Rezoning Transportation Analysis

Petition Number: #2023-018

Date	Description
06-22-23	First Review (TM)
11-27-23	Second Review (ME)
12-20-23	Third Review (TM)

**RZ-1**

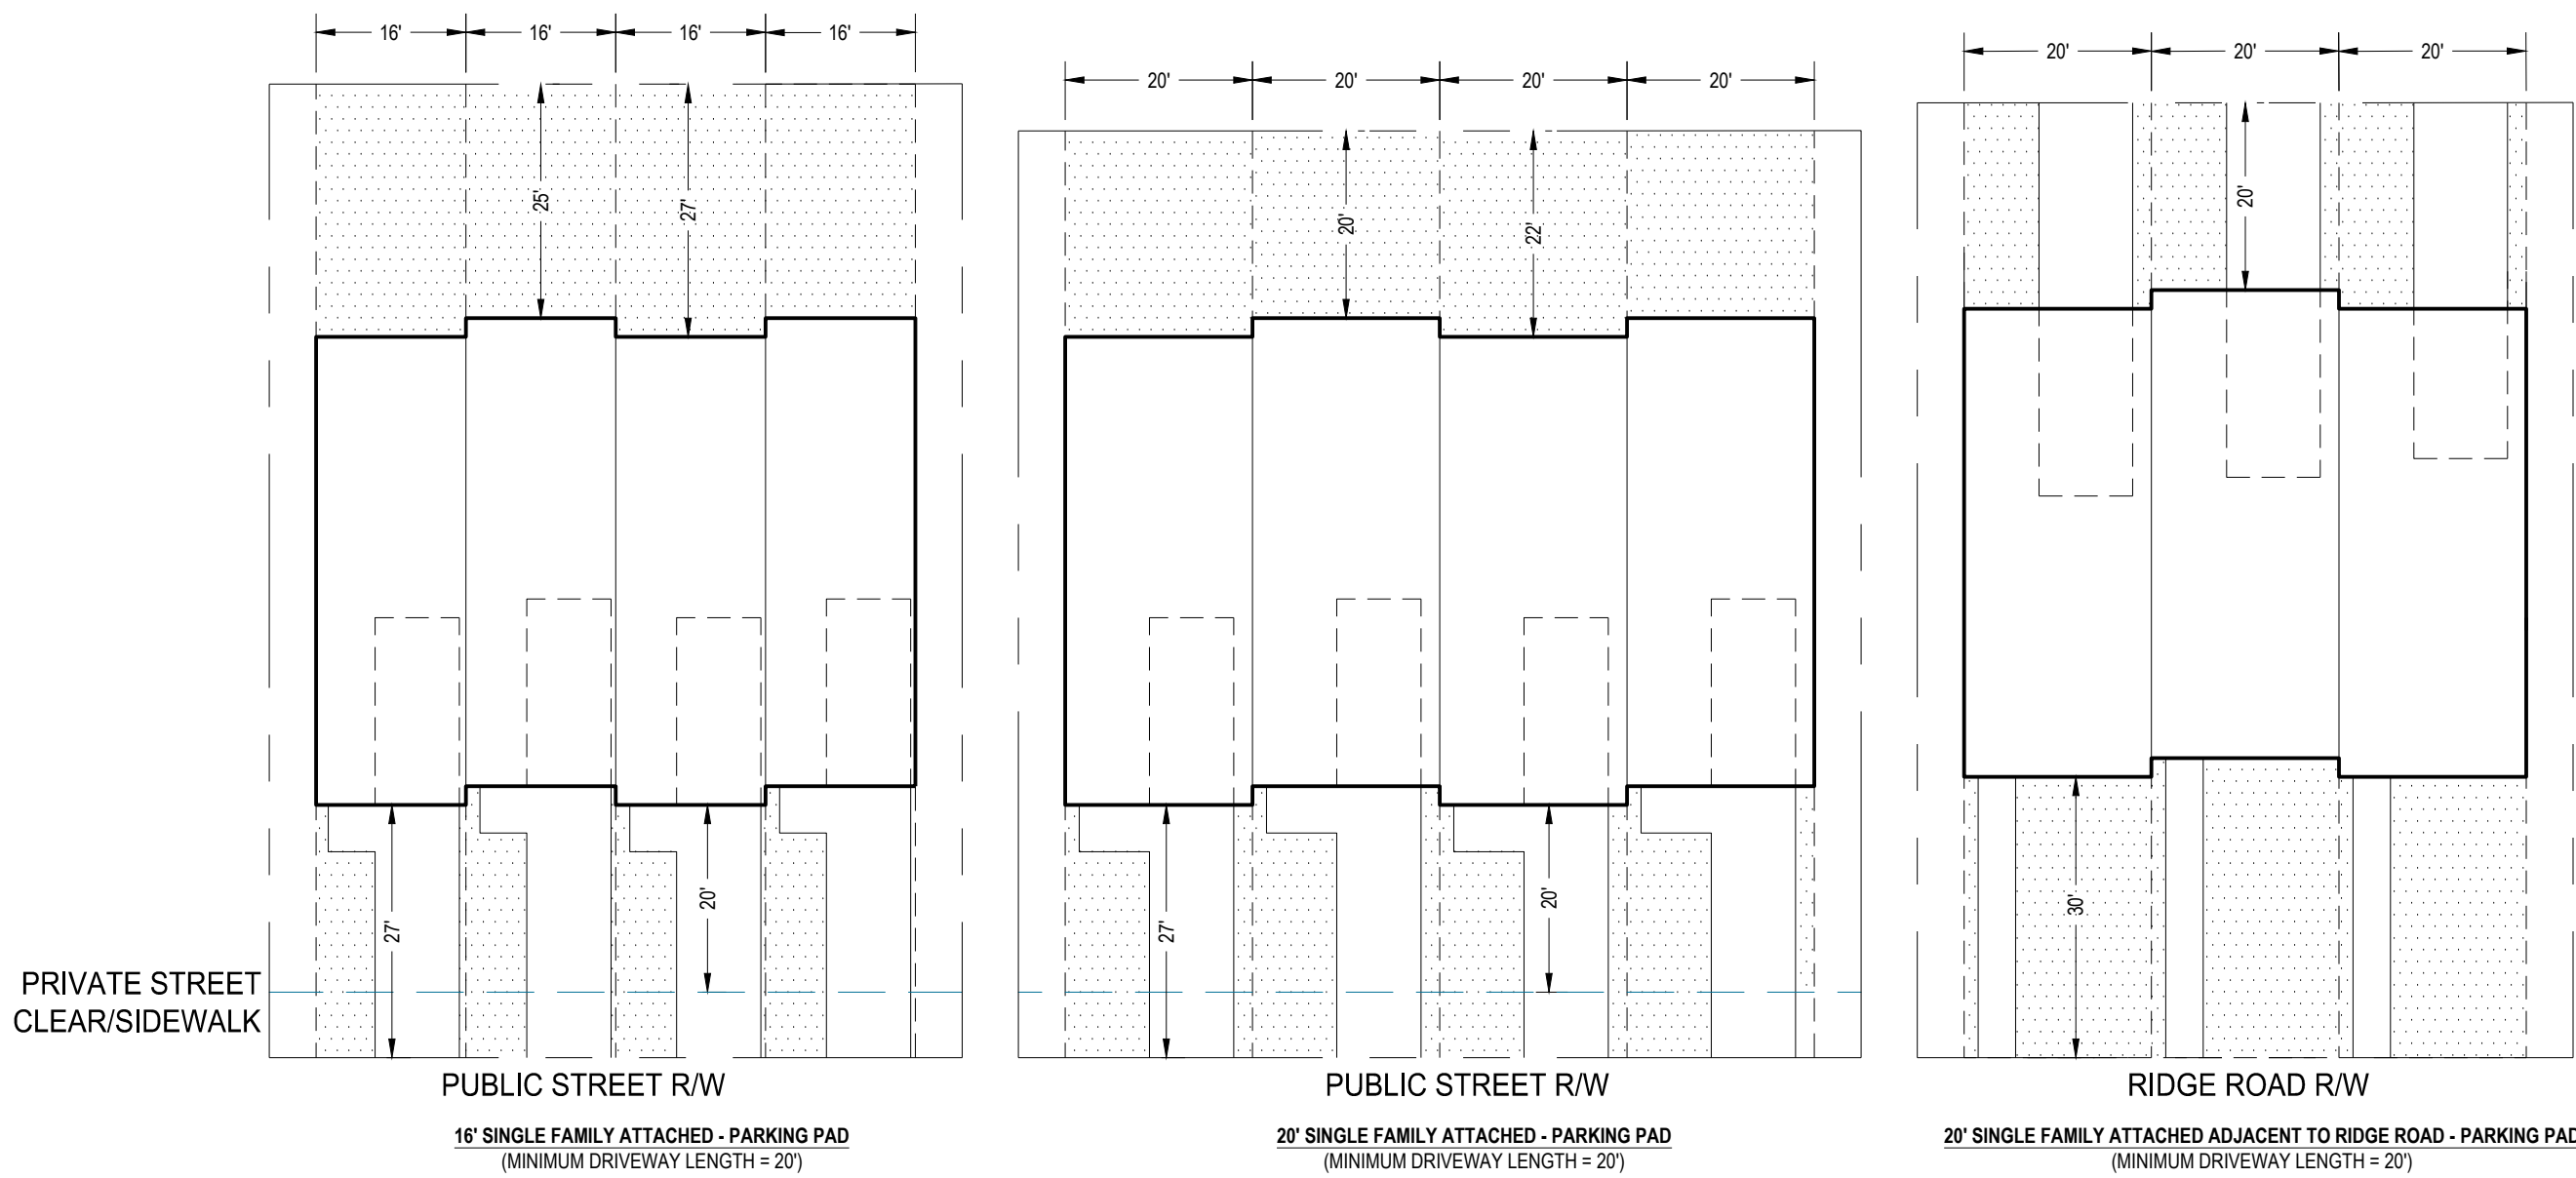
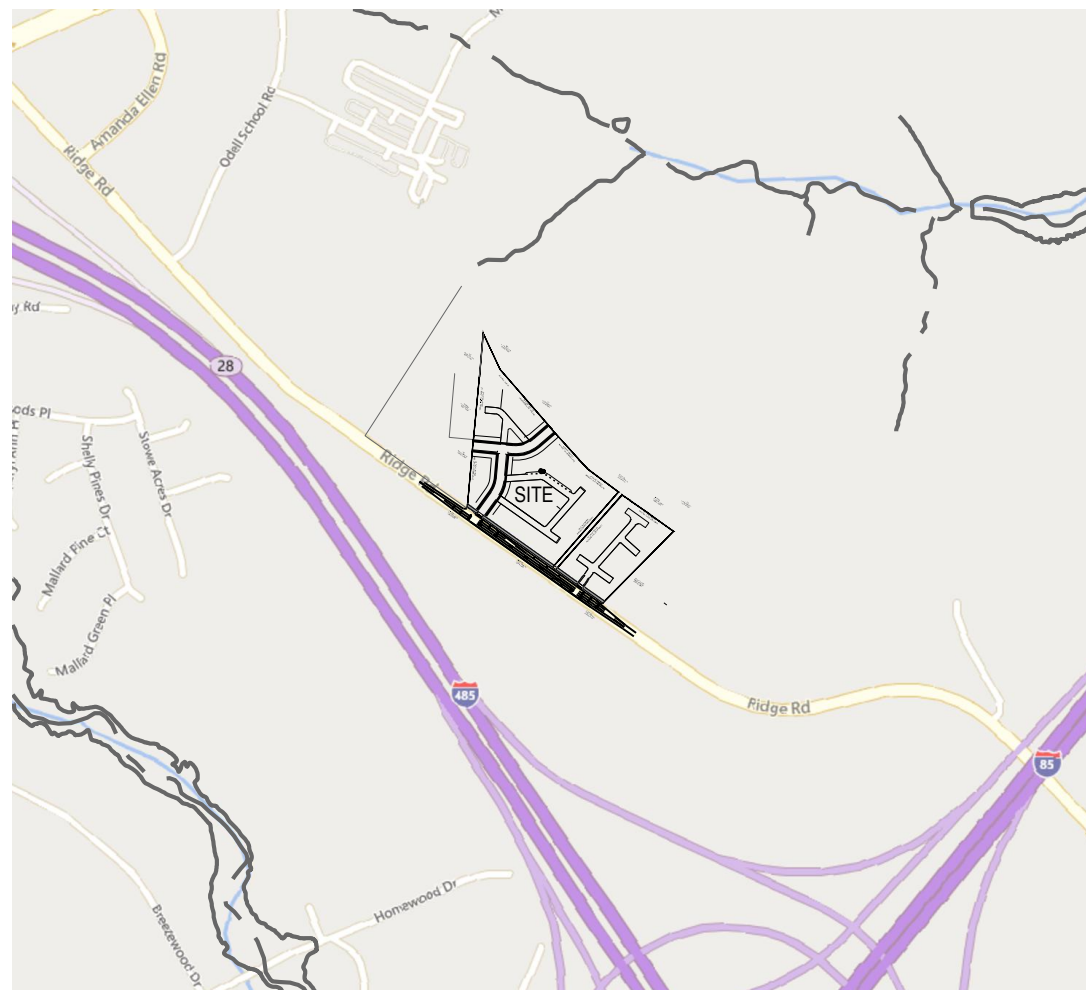
Comment 11-27-23: Please revise site plan to show that 12 ft SUP is not within public right of way. The dedicated right of way callouts should also be revised to show that 38 ft is dedicated to the public and not 50 ft. SUP may be constructed within the right of way if the site is annexed into the City.~~

RZ-1

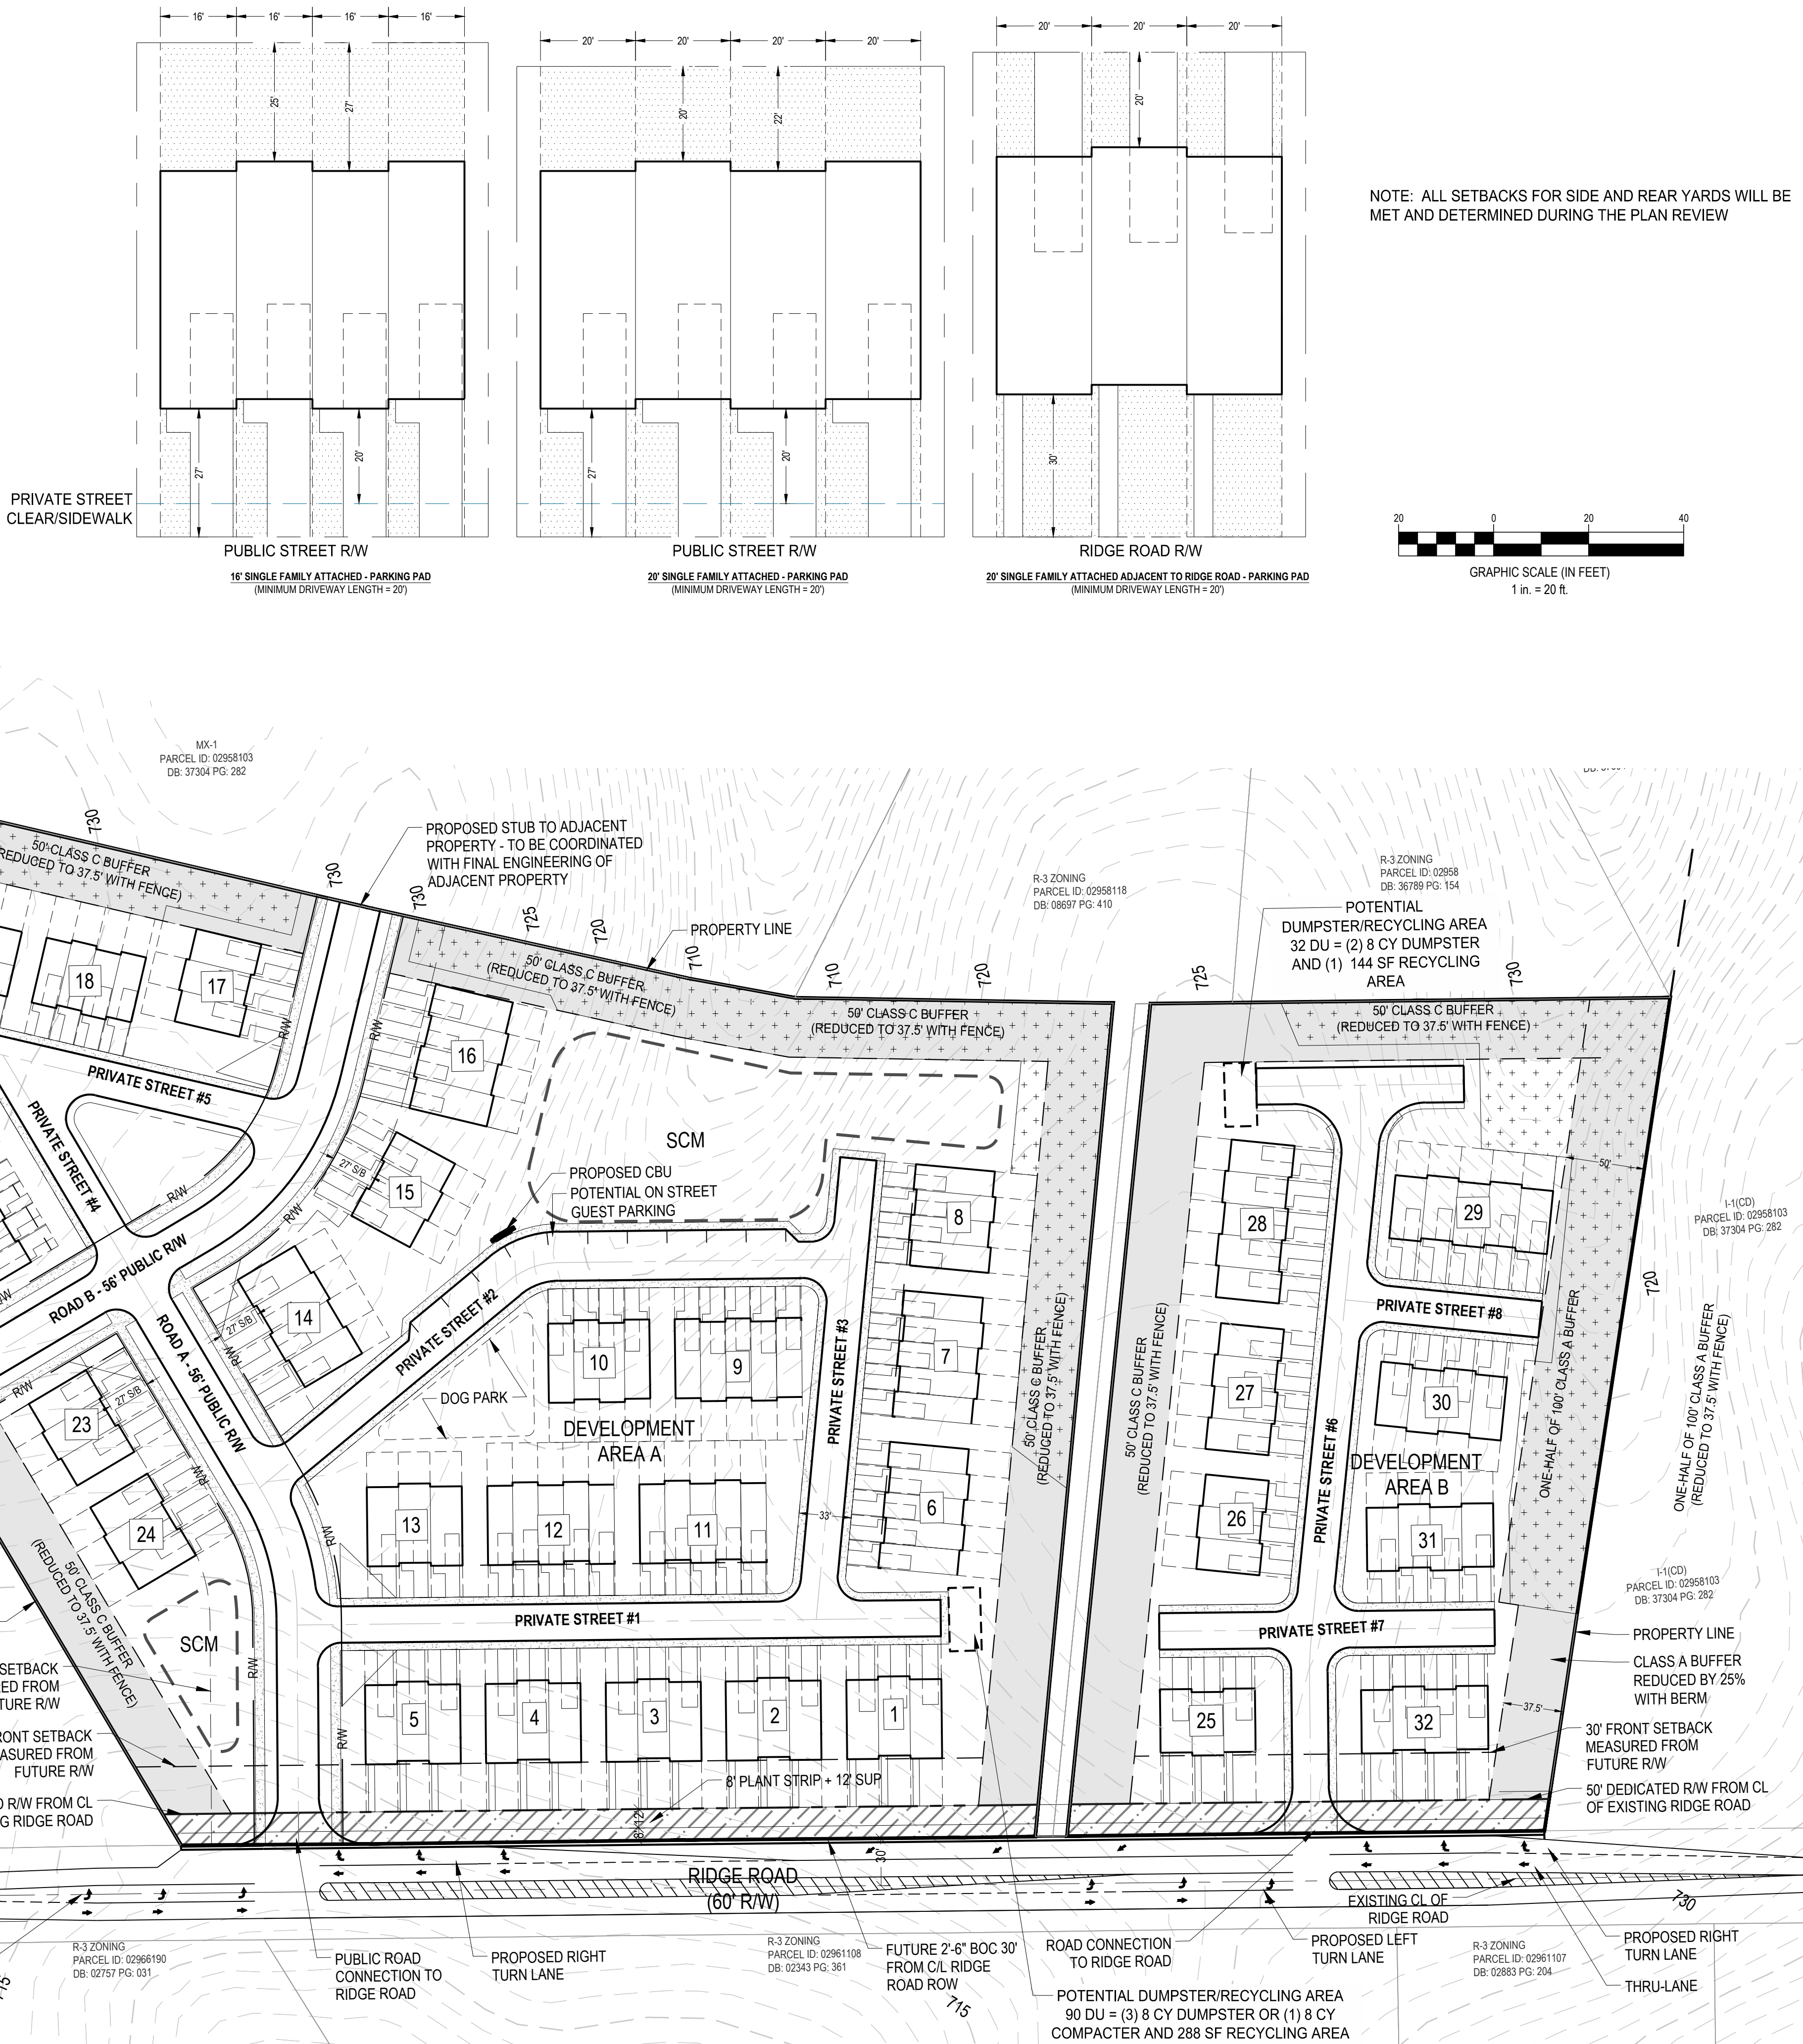
5. ~~Revise site plan and conditional note(s) to commit to widening Ridge Road to accommodate a two-way left turn lane and dedicated right turn lane at the sites frontage in coordination with NCDOT.

Comment 11-27-23: Site plan does not show two-way left turn lane, please adjust to show this on the site plan.~~
6. ~~Revise site plan and conditional note(s) to commit to coordinating internal roadway network with Kings Grant rezoning 2023-024.

12. ~~Revise site plan and conditional note(s) to construct 8 foot planting strips and 12 foot multi-use paths on Ridge Road. The site plan shall label and dimension both items from the back of curb and gutter or edge of pavement. Add conditional note The entire facility must be outside of the right of way and within a public access easement. Add conditional note committing to construction and maintenance of the 12-foot multi-use paths on Ridge Road.
